**The Sandstone Precinct, 23-33 & 35-39 Bridge Street, Sydney
(SSD 7484 and SSD 6751 MOD 2) - Response to Submissions**

Thank you for your letter dated 2 May 2017, requesting Transport for NSW (TfNSW) review and comment on the above.

Objective Reference: CD16/04852

The vehicle manoeuvring paths for the SRV and van are shown in Figure 8 to Figure 11. This shows that all vehicles will be able to enter and exit the building in a forwards direction.

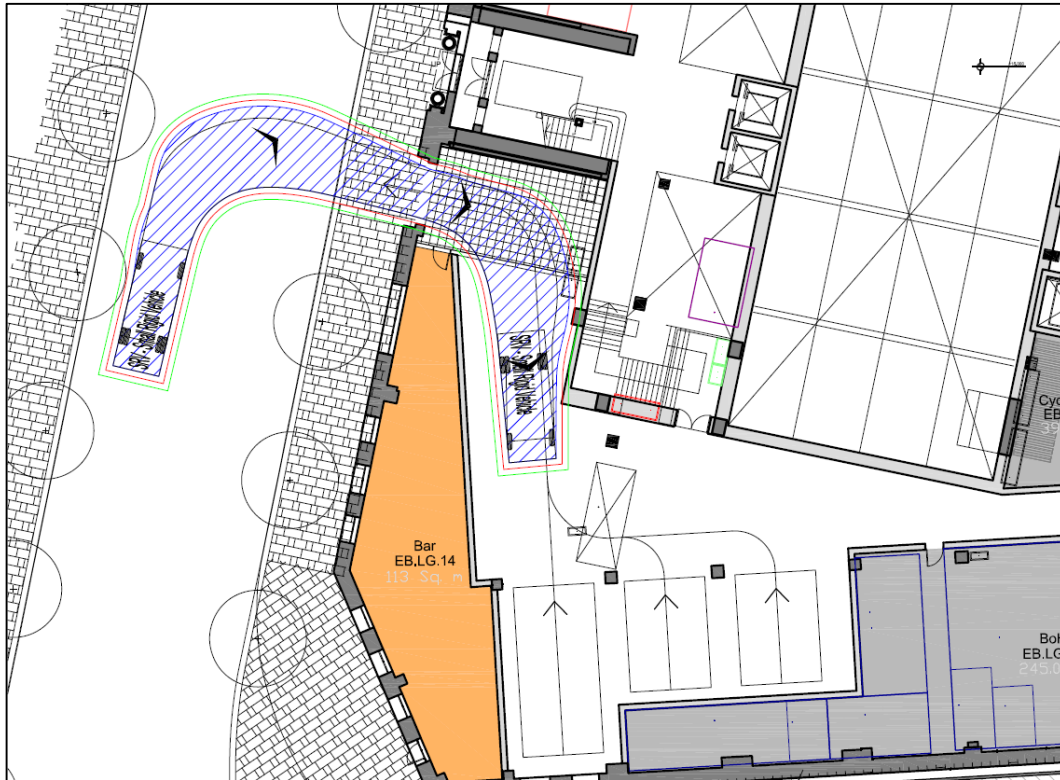
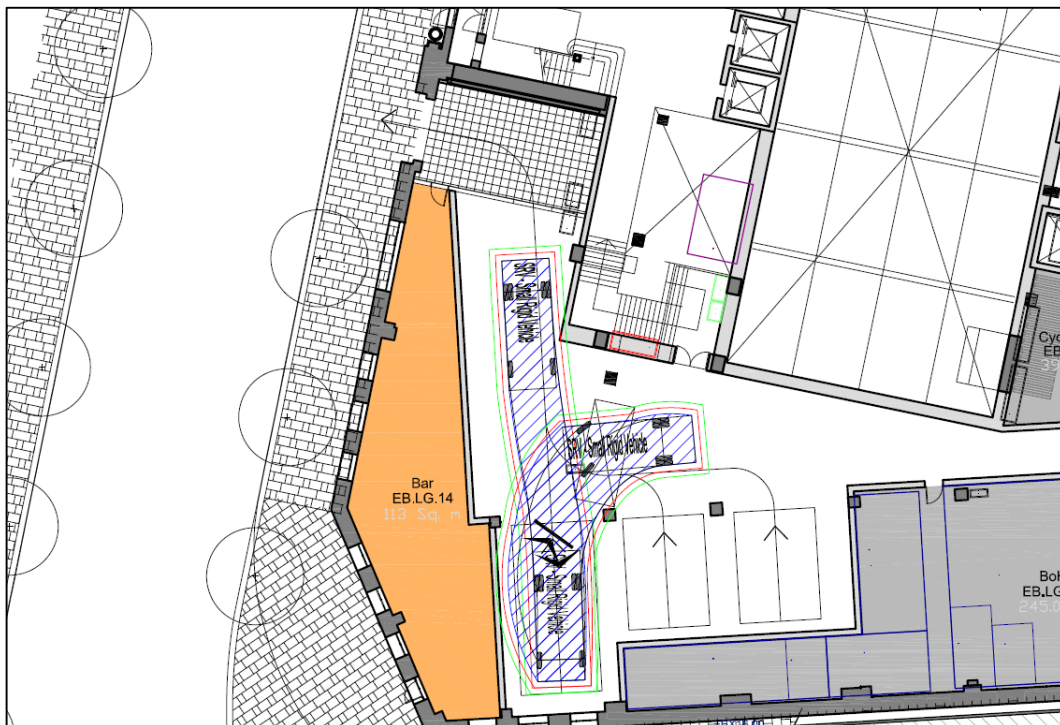
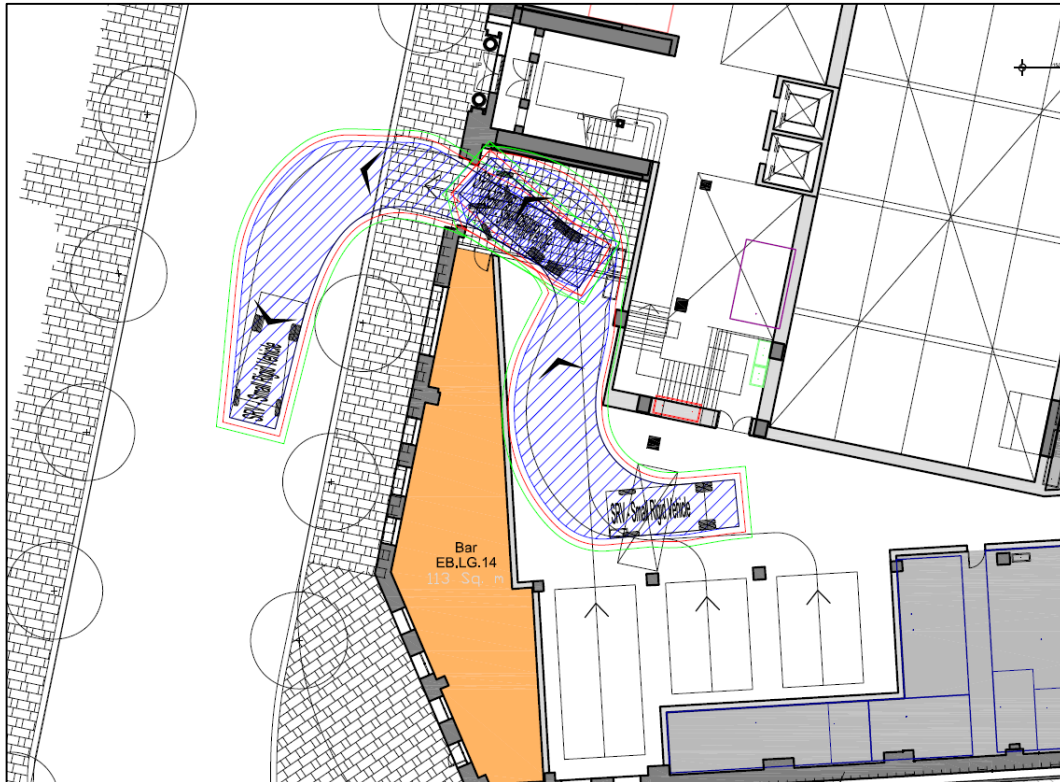
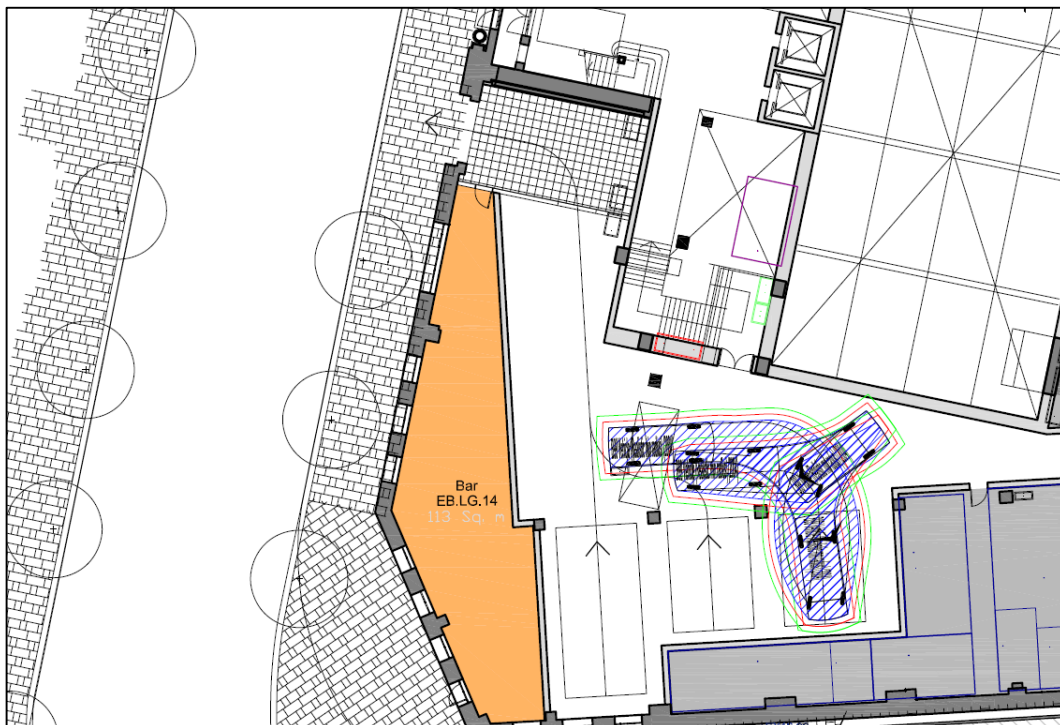
TfNSW notes that the swept path analysis has been undertaken for a 12.5m design vehicle. TfNSW advises that the swept path analysis should be revised using a 14.5m bus as the design vehicle and include all bus movements.

- Consult with the City of Sydney and the CBD Coordination Office within TfNSW in regard to the kerbside controls, taxi zone and hotel drop off; and
- Revise the swept path analysis with a 14.5m bus as the design vehicle and include all bus movements.
